# BICESTERBUG

## **Submissions on proposed housing in NW Bicester**

**21/01630/OUT**

**22 June 2021**

CLIENT: Firethorn  
 PROJECT: North West Bicester  
 DRAWING: Illustrative masterplan  
 PROJECT NUMBER: I192  
 DRAWING NUMBER: SK004 CHECKED BY: MI/LA  
 REVISION: C STATUS: Draft  
 DATE: 14/04/2021 SCALE: 1:2,000

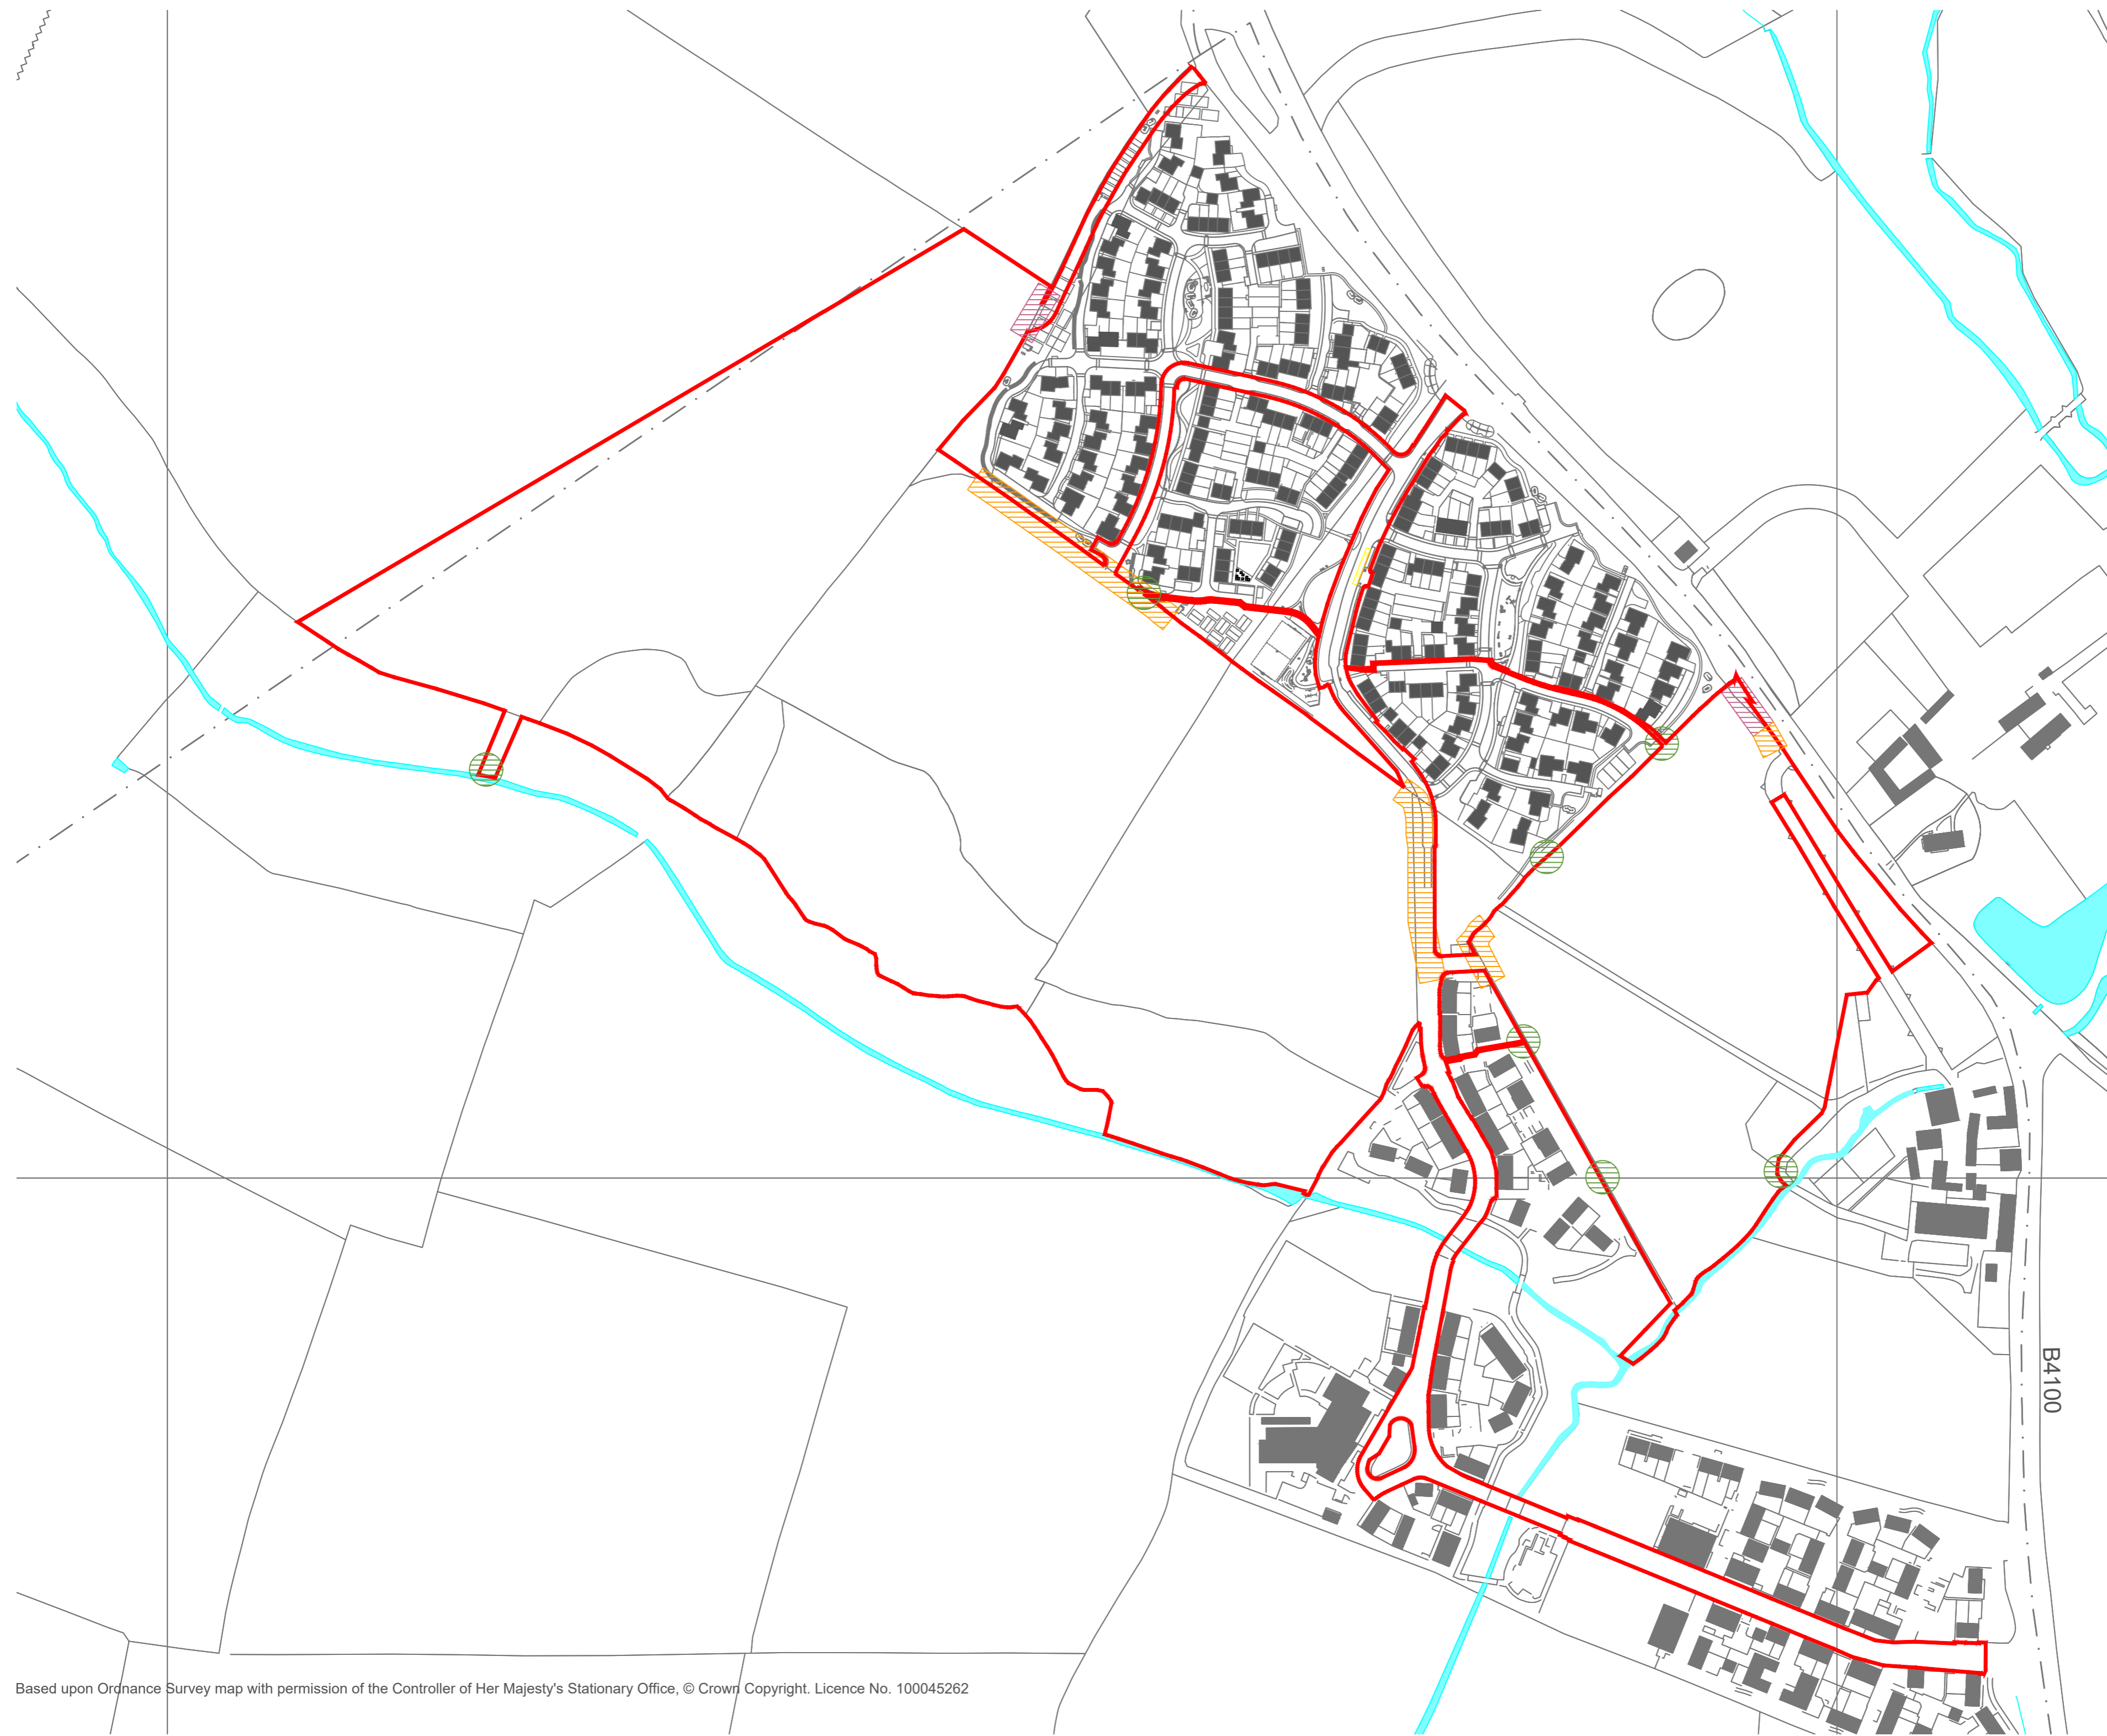
Although prominence is given to maintaining a view of St Lawrence's Church, no provision for active travel access is made to actually access the church. This is a serious oversight and ought to be remedied.

In order to connect to neighbouring communities, active travel links to the site via Aunt Ems Lane (the lane between the B4100 and the Fringford Road) should be included in the plans. BicesterBUG rejects the notion that the Fringford road offers a suitable route, as outlined above. We reiterate that one low cost possibility would be to provide a dedicated active travel corridor between NW Bicester and Caversfield by closing Aunt Ems Lane to motor vehicle traffic. We note that the developer has assessed the connection (in ES vol 2 Appendix 6.1 and 6.2 Transport assessment), we disagree with the assessment and contend that with minor changes suitable active travel provision can be constructed. The reasoning that the existing route via skimmingdish lane is shorter than an alternative via Aunt Em's lane and the east development parcel (e.g. via Home Farm) is not proven

Alternatively, Aunt Ems Lane could be made one-way for motor traffic from the B4100 to the Fringford Road to maintain access, allowing the current E-Bound lane to be segregated into a bi-directional active travel route. This option would provide safe access between the proposed development, Caversfield, the church and the school. The addition of a path along the eastern side of the B4100 from aunt em's lane to St Lawrence Church and a crossing to the proposed development site would make a valuable addition to the active travel connectivity of the development and the wider area. This would unlock active travel access to the church which is currently not possible from Elmsbrook or Caversfield.
